**Subject:** Rezoning Petition Review

**Date of Review:** July 28, 2022 (***Revised August 17, 2022***)

**Rezoning Petition #:** 22-032

**Location of Property:** Approximately 4.18 acres located on the north side of W Arrowood Rd, east of Forest Point Blvd and west of Nations Ford Rd.

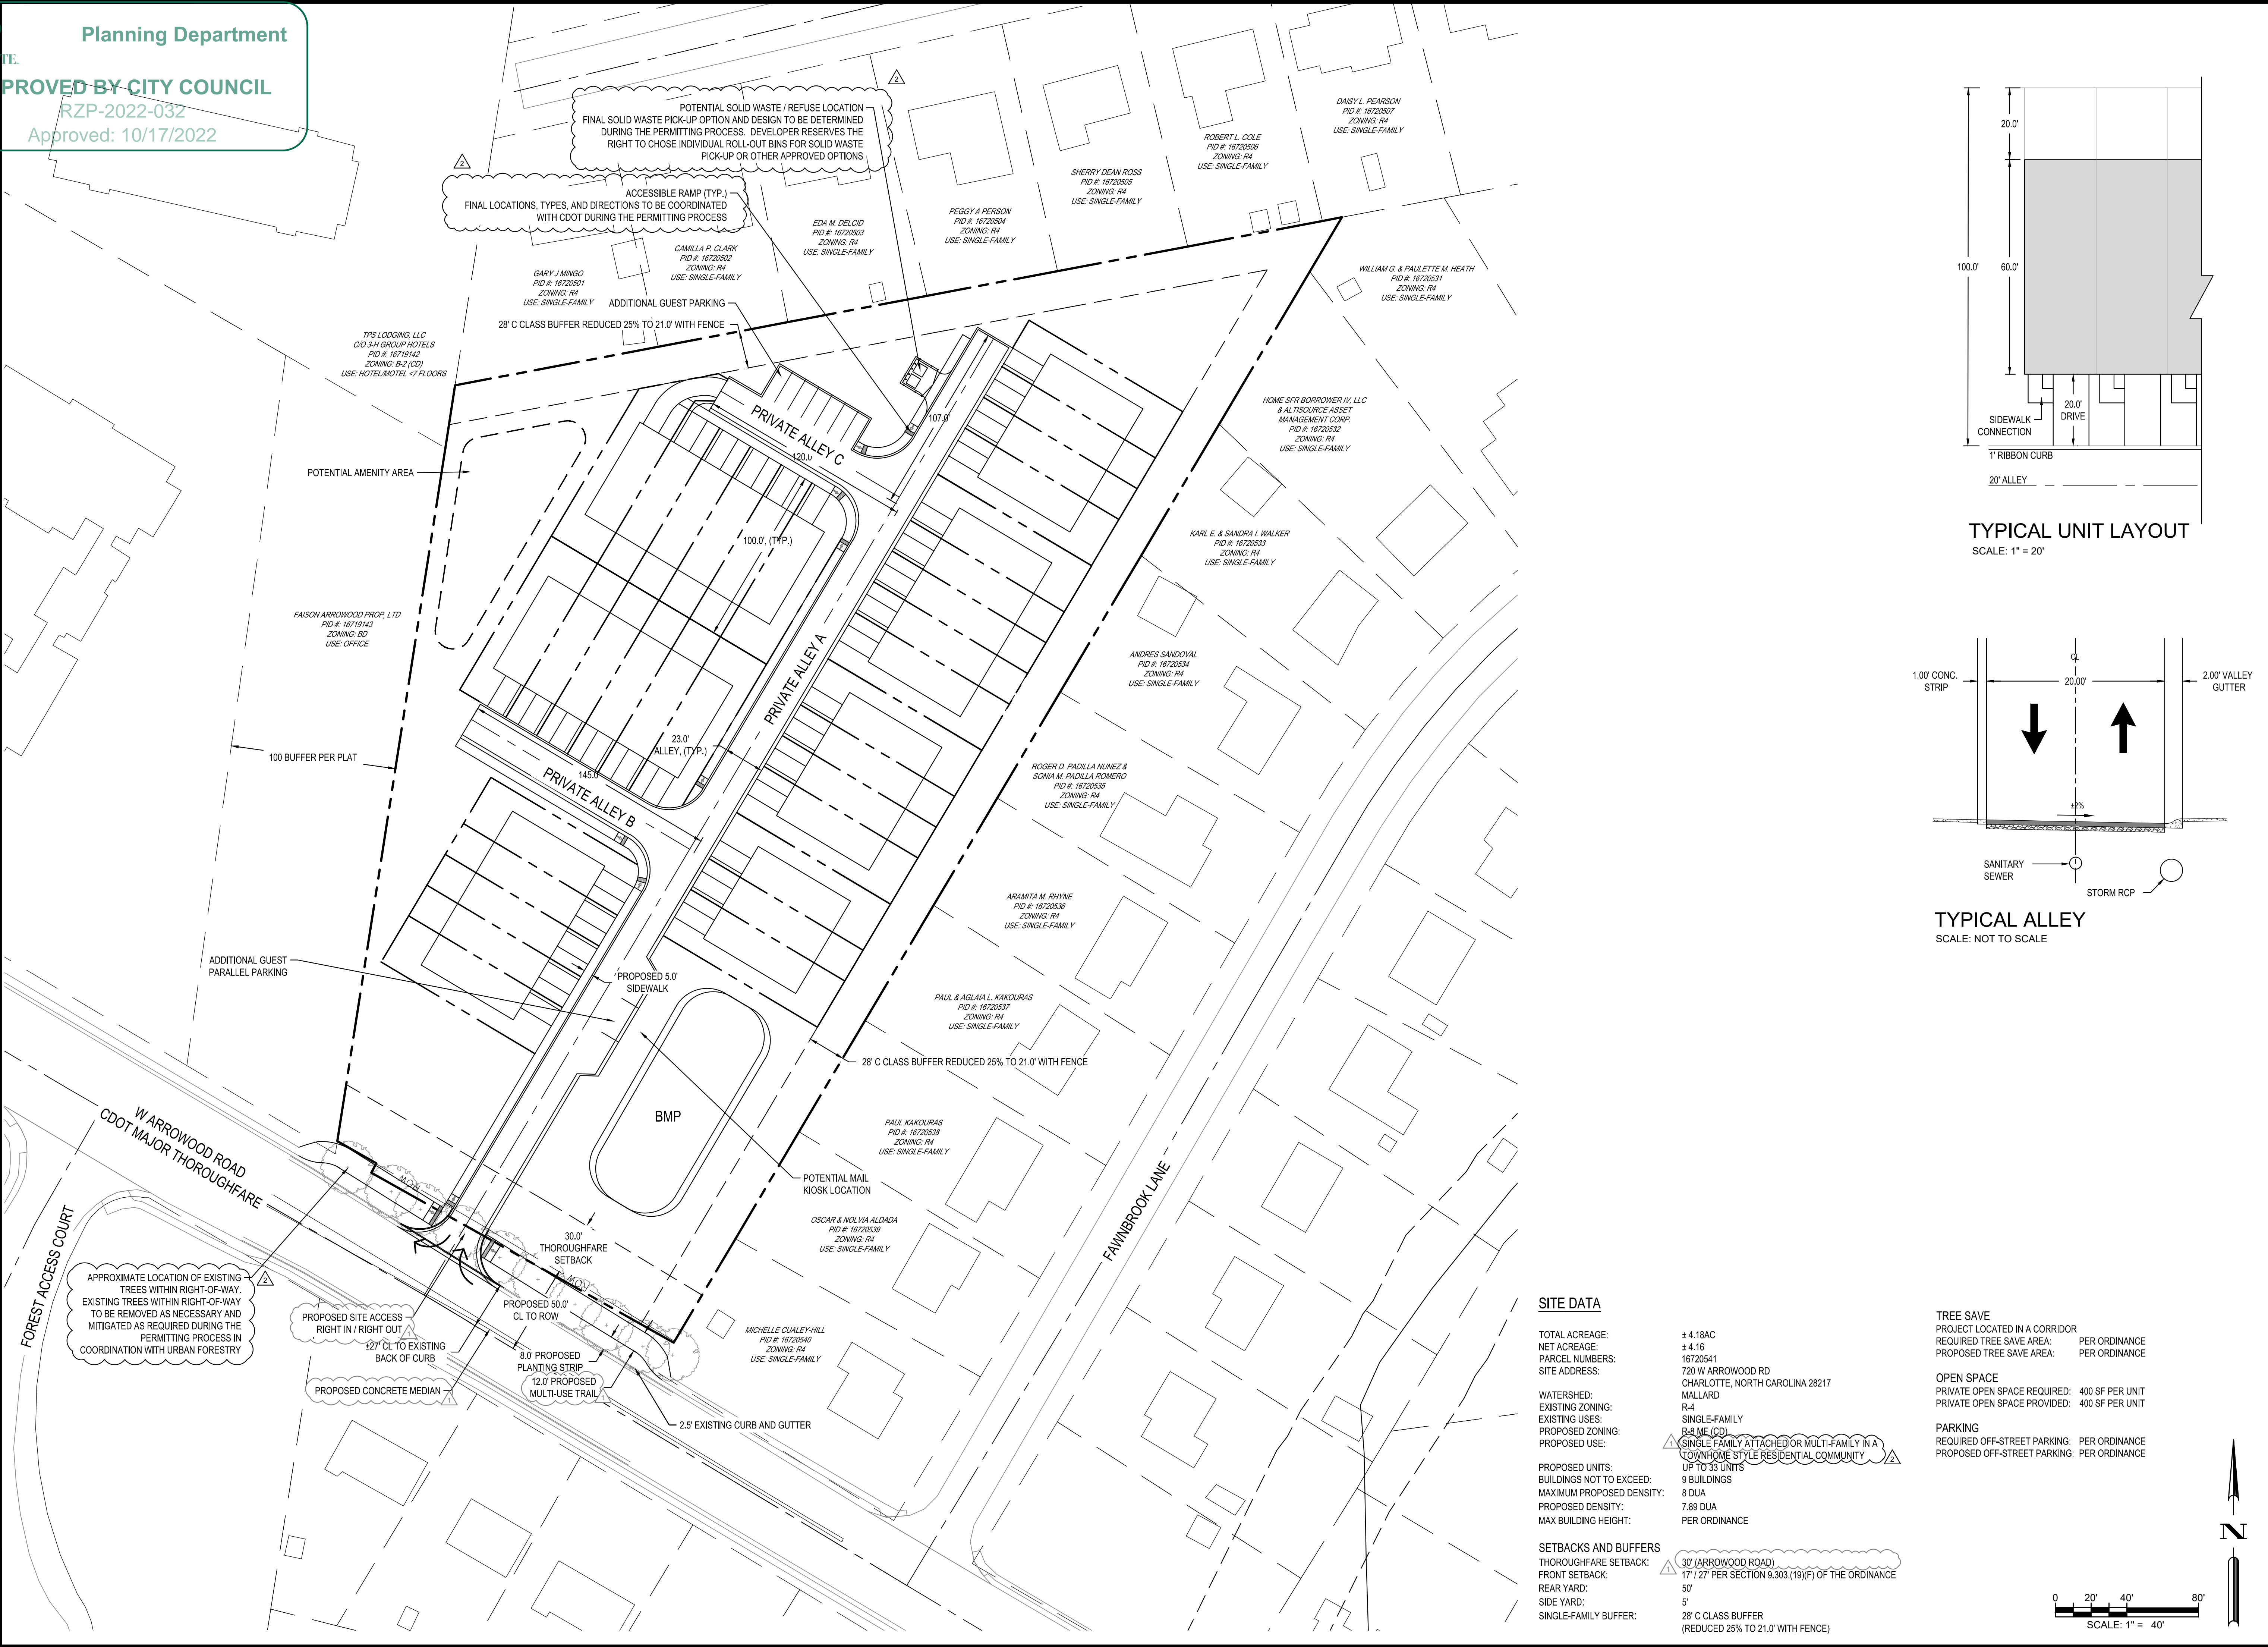
**Concerning Storm Water:** City of Charlotte GIS indicates a potential drainage feature through the site. Please include the following note under Environmental Features: *“Development within any SWIM/PCSO Buffer shall be coordinated with and subject to approval by Charlotte-Mecklenburg Storm Water Services and mitigated if required by City ordinance. Petitioner acknowledges intermittent/perennial stream delineation reports are subject to review and approval upon submission of development plans for permitting and are not approved with rezoning decisions.”*
